RESPONSE TO SUBMISSIONS REPORT

SSD 34919690 – MOD 2
39-43 HASSALL ST PARRAMATTA

APRIL 2025

Deep Soil diagram

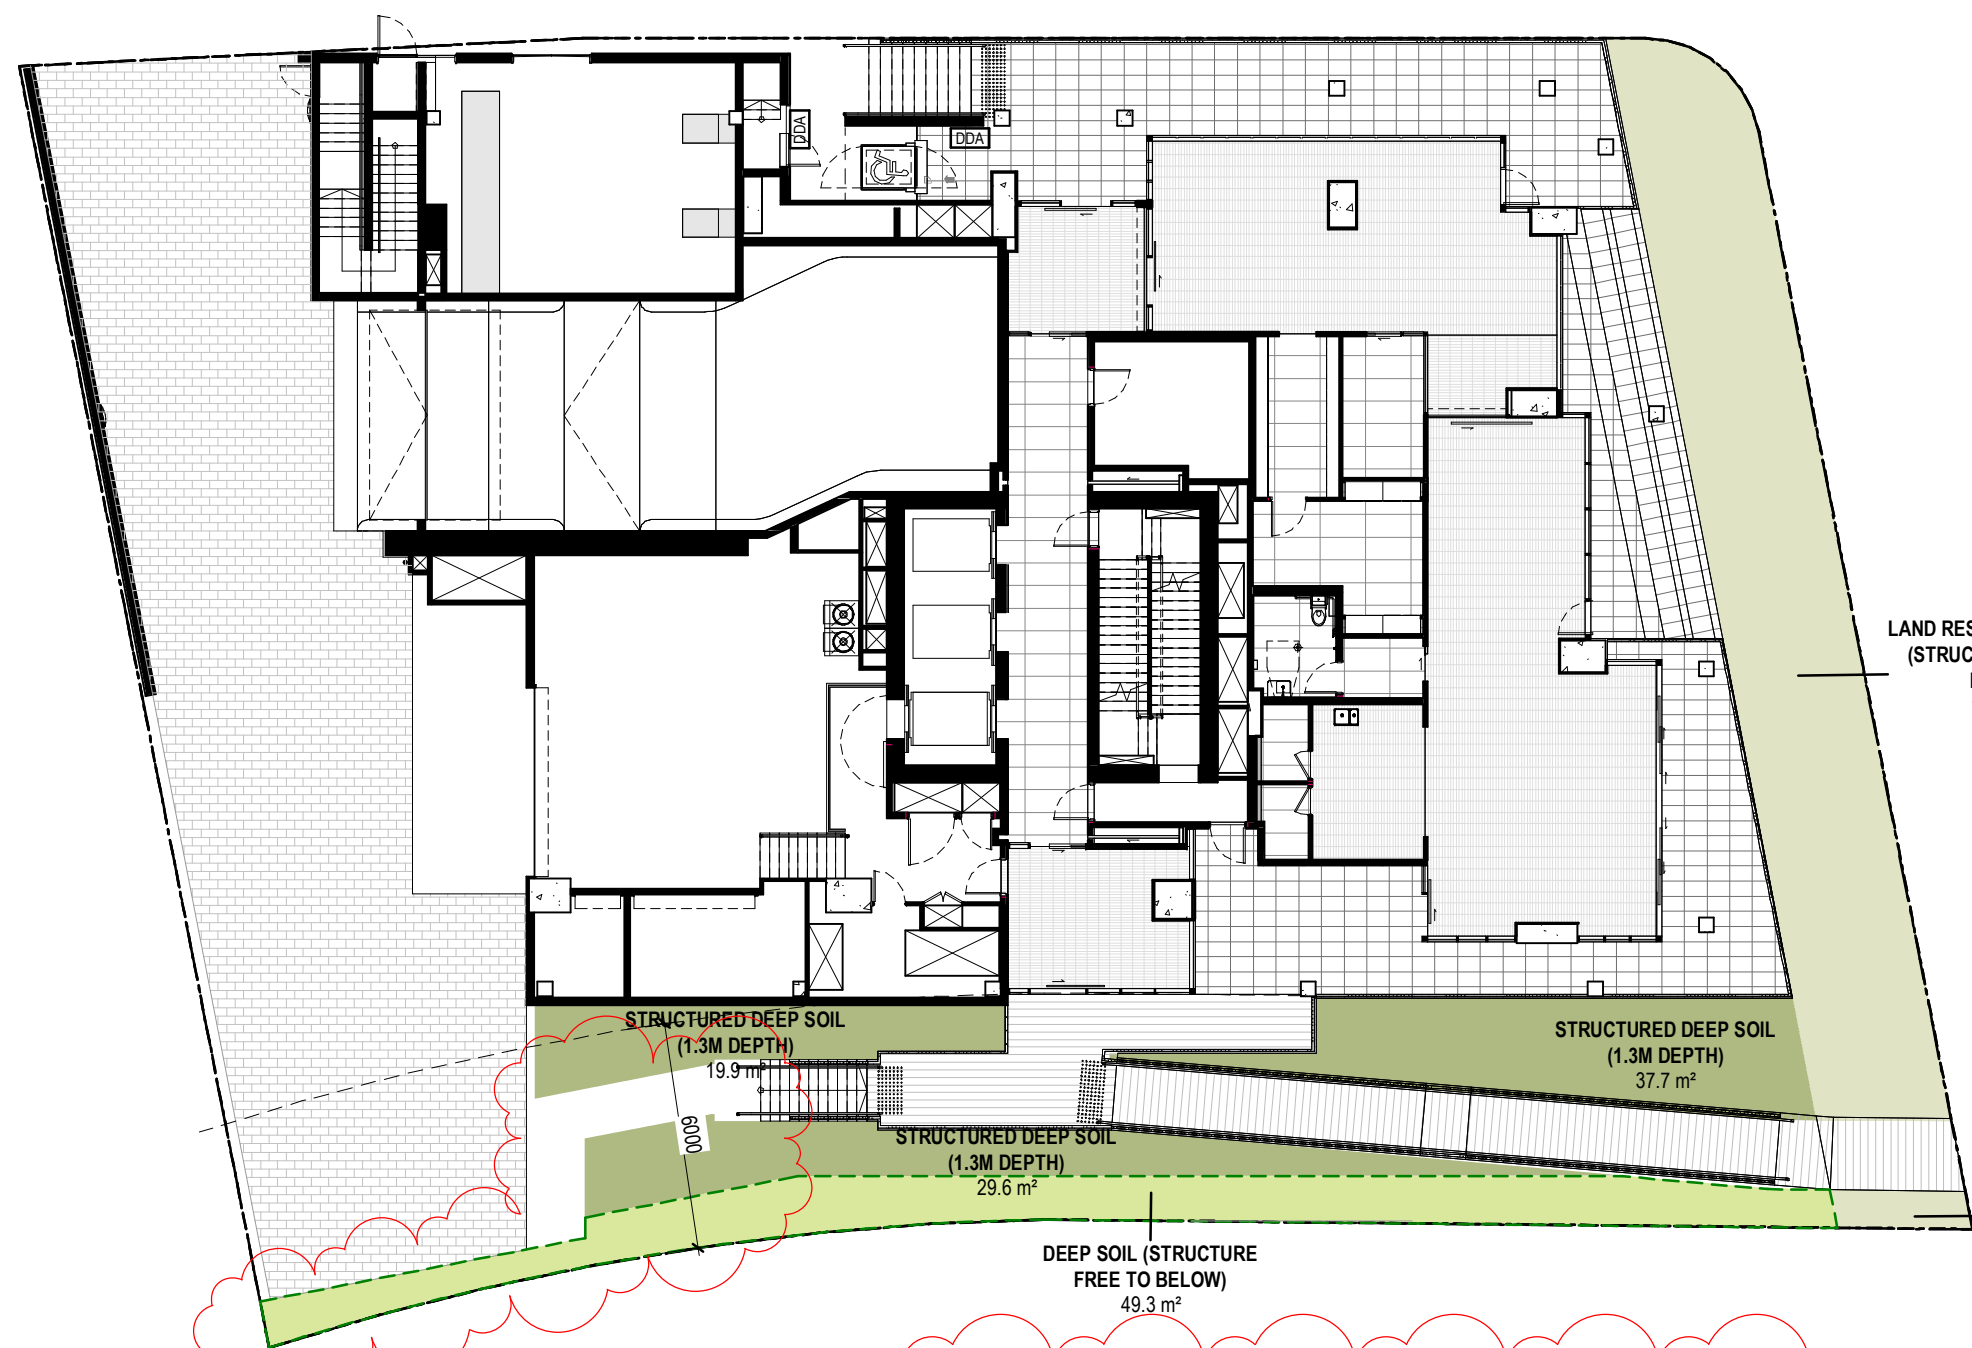
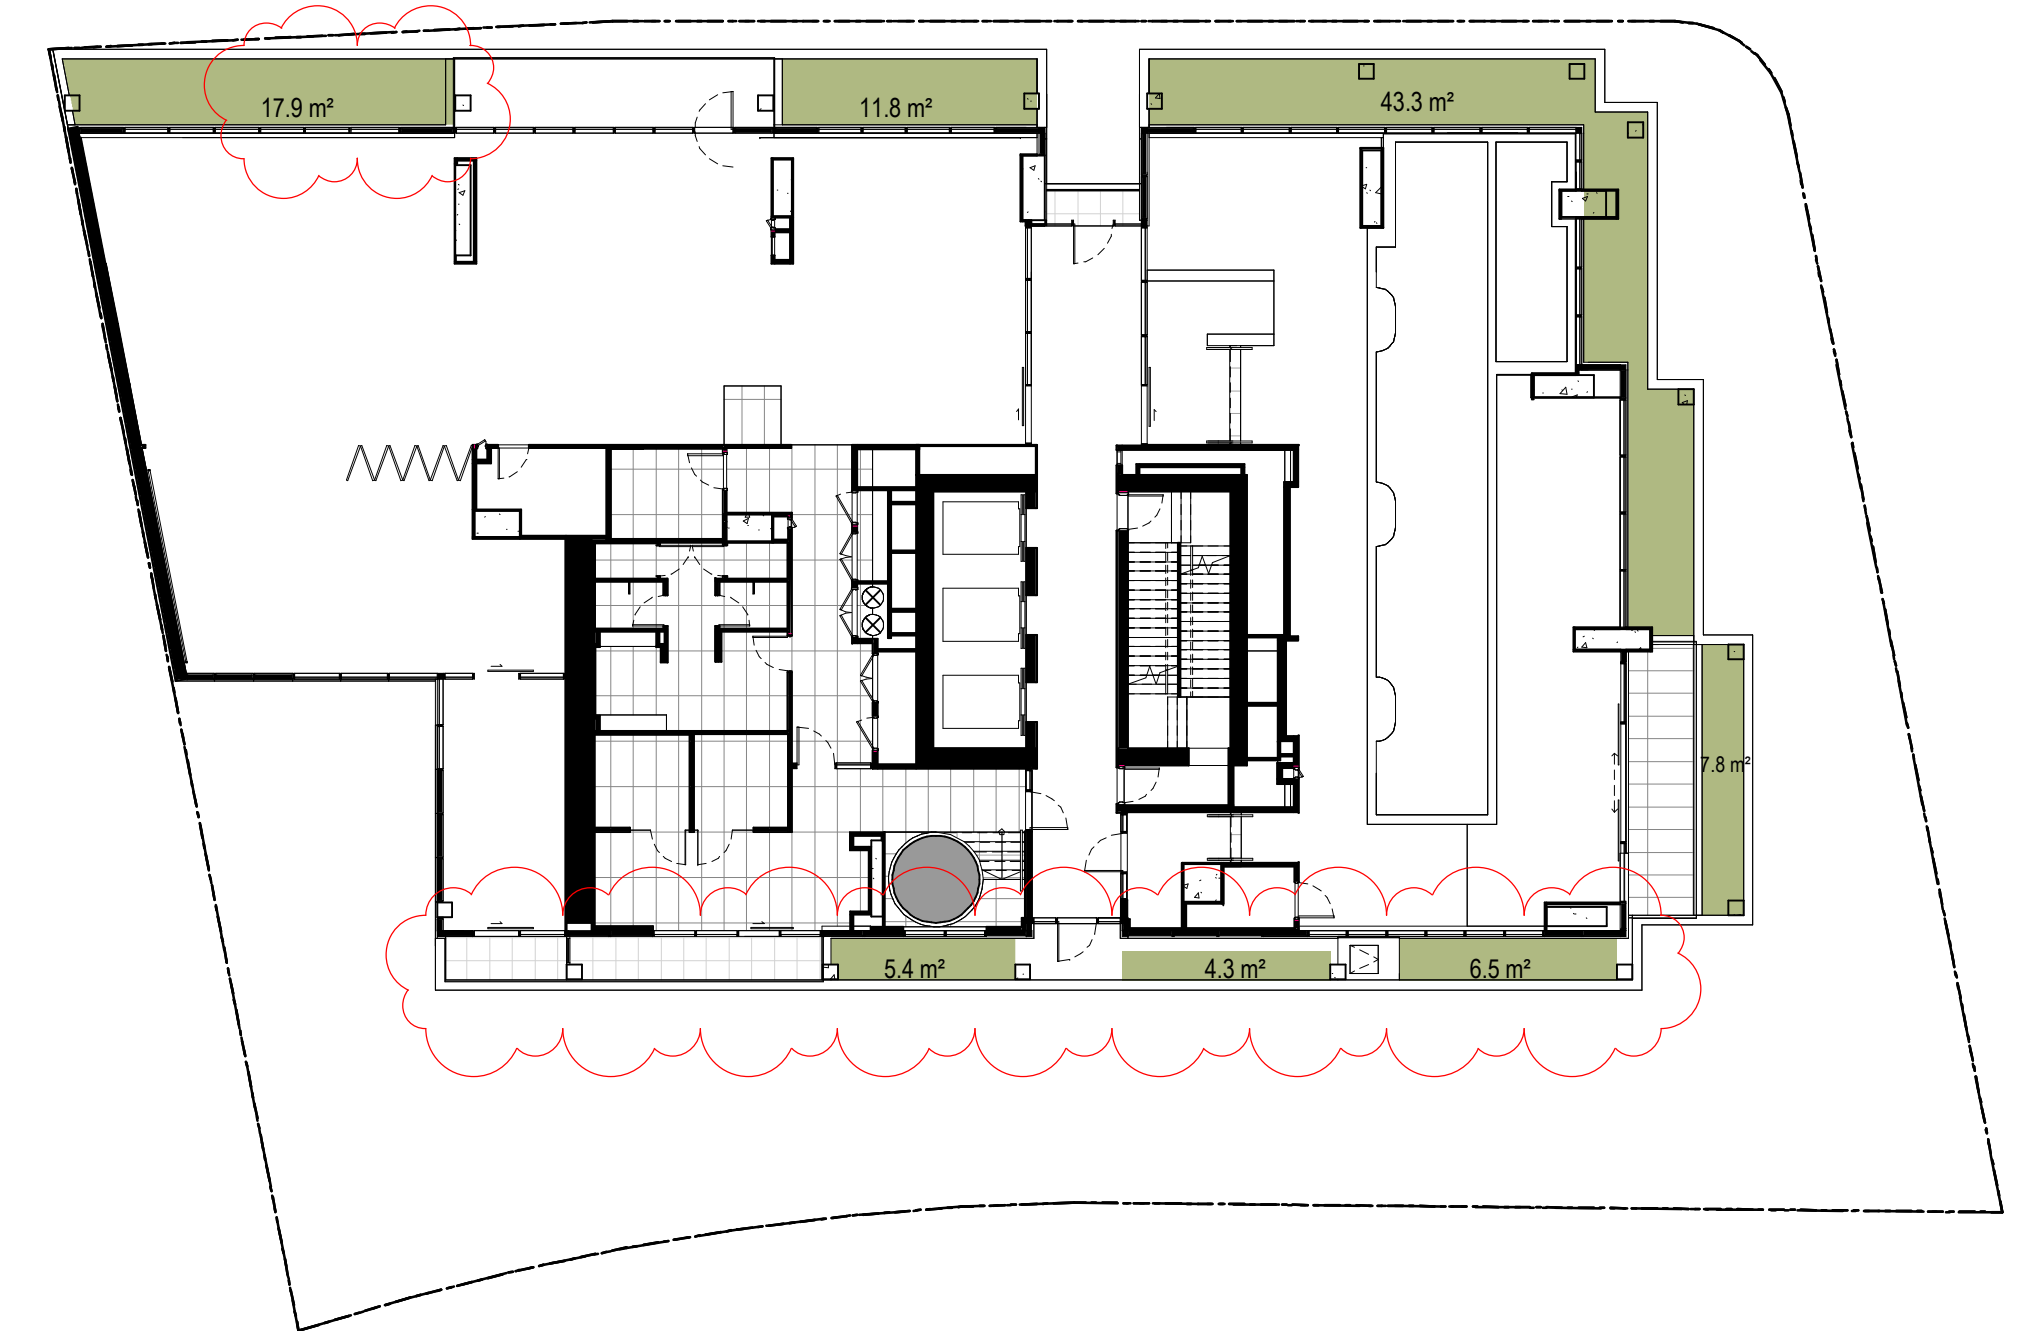
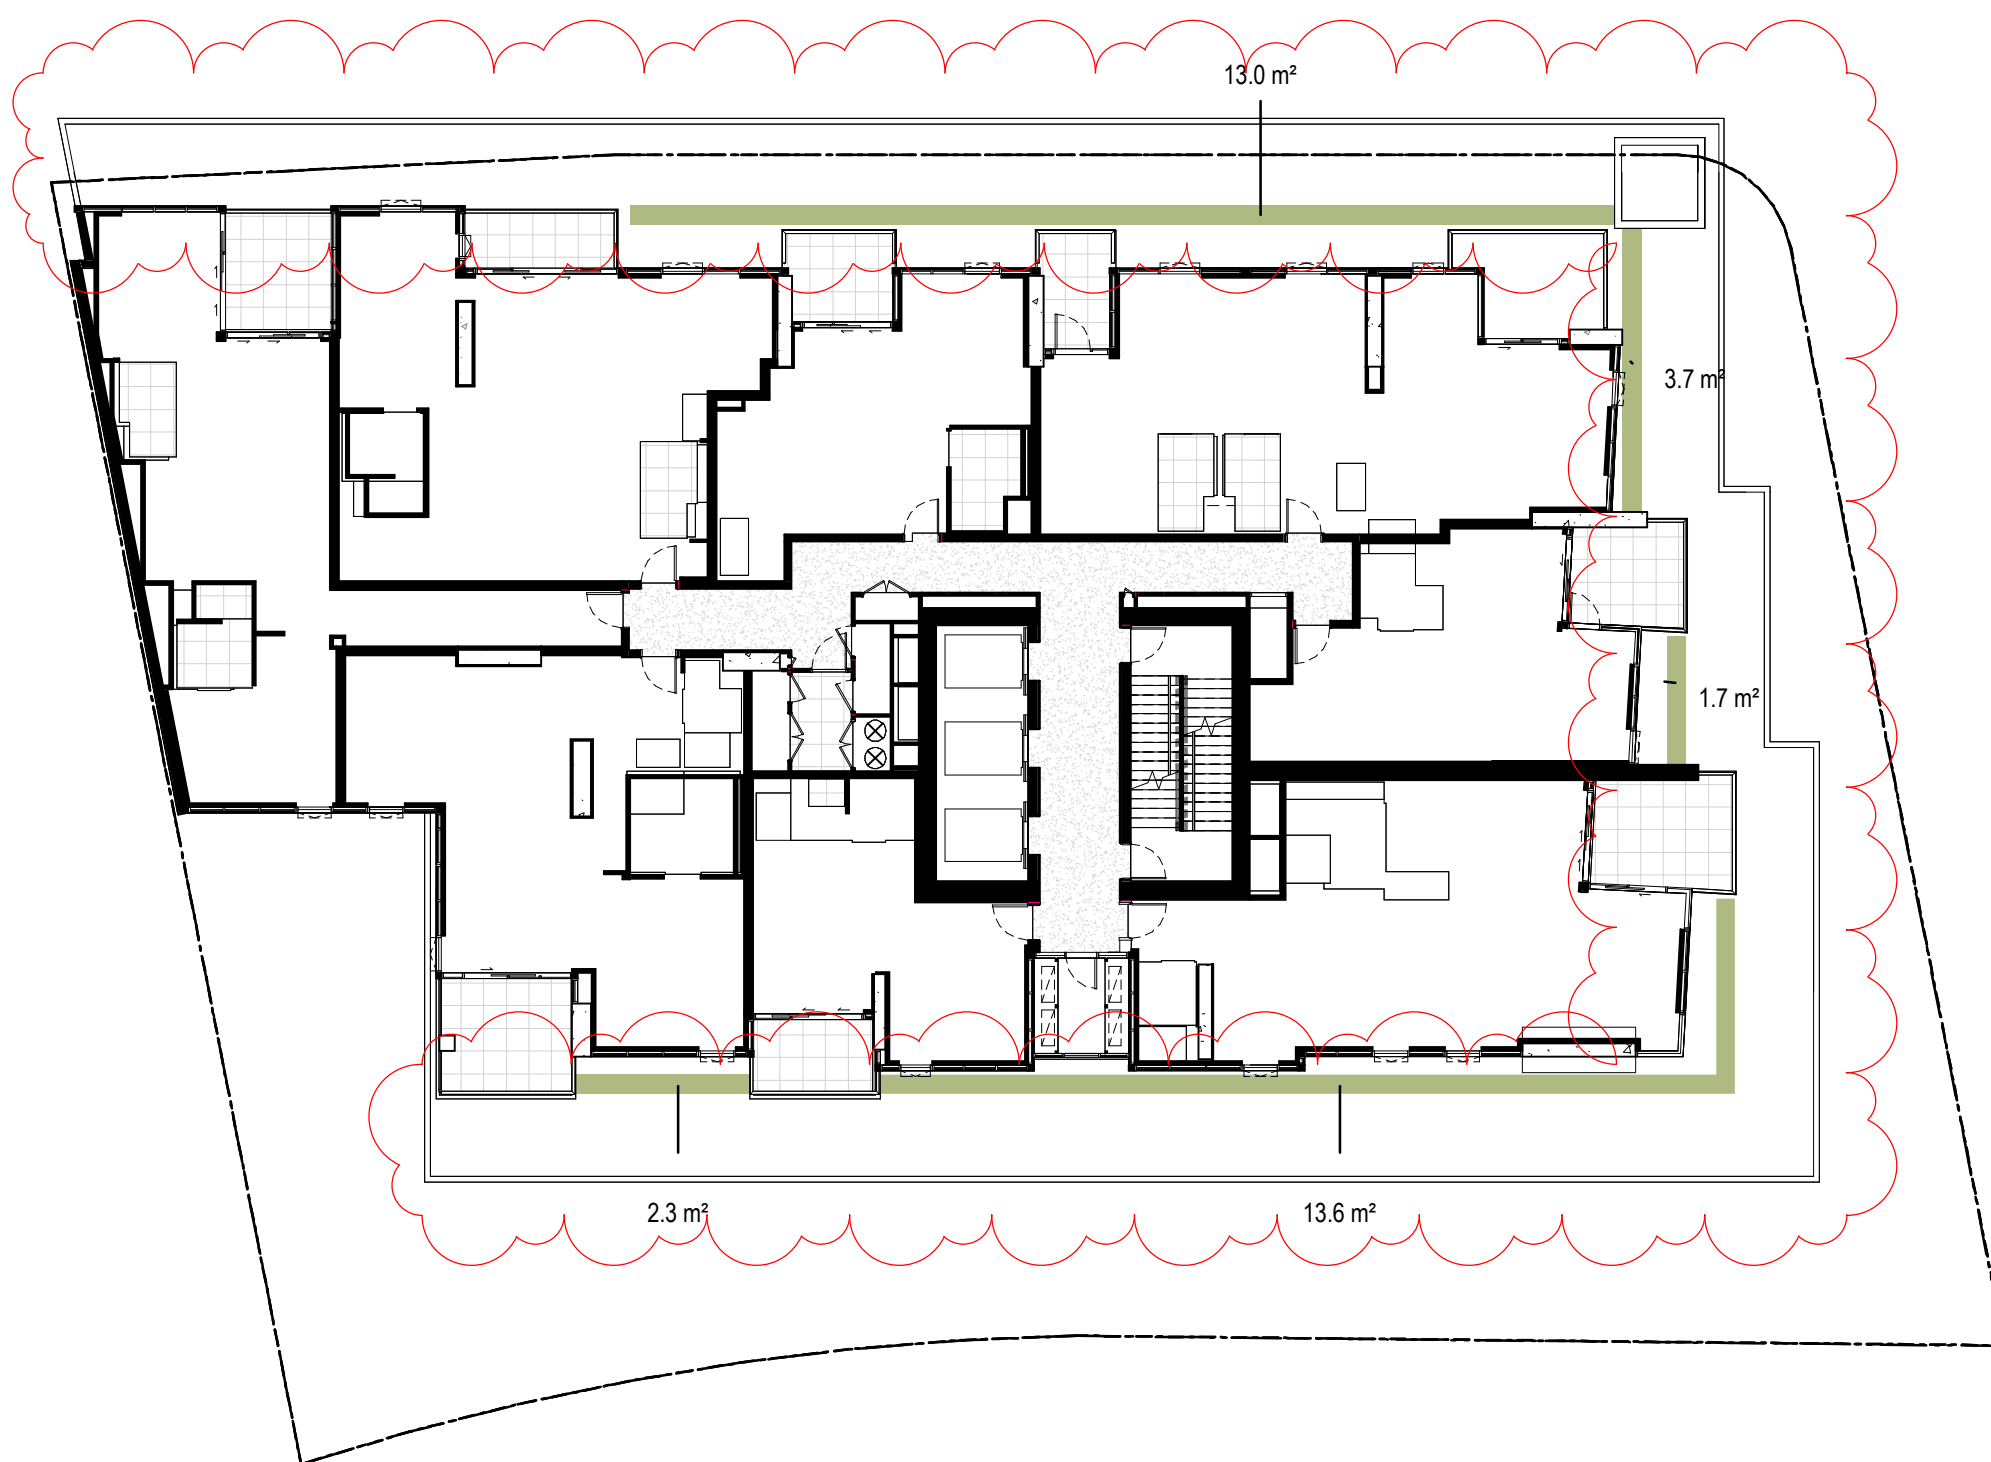
○ Section A of the landscape report does not show the basement structure only 1.2m from the boundary extent, below the proposed planting strip/riparian zone. ○ Planting on structure details are to be provided showing substrate depth, drainage, waterproofing for all planting on structures, including planting over the basement at ground level. ○ Soil volume, depth and soil areas on podium and over the basement must meet the following prescribed standards in the Apartment Design Guide (ADG) – Part 4, 4P <i>Planting on Structures – Tools for improving the design of residential apartment development</i> (NSW Department of Planning and Environment, 2015): ▪ Typical tree planting on structure detail to show overall 800-1200mm soil depth. ▪ Soil volume to be reflective of proposed tree species size	The landscape plan has been amended to show basement extent in Section A. Please see attached amended plans for details. Planting on structure details has been provided on Sheet 701 please see attached landscape plan for further details. Trees are only proposed within the ground floor. Planting on structure diagram has been provided on page 15. Soil Depth and volume are both compliant with the provisions of the ADG.
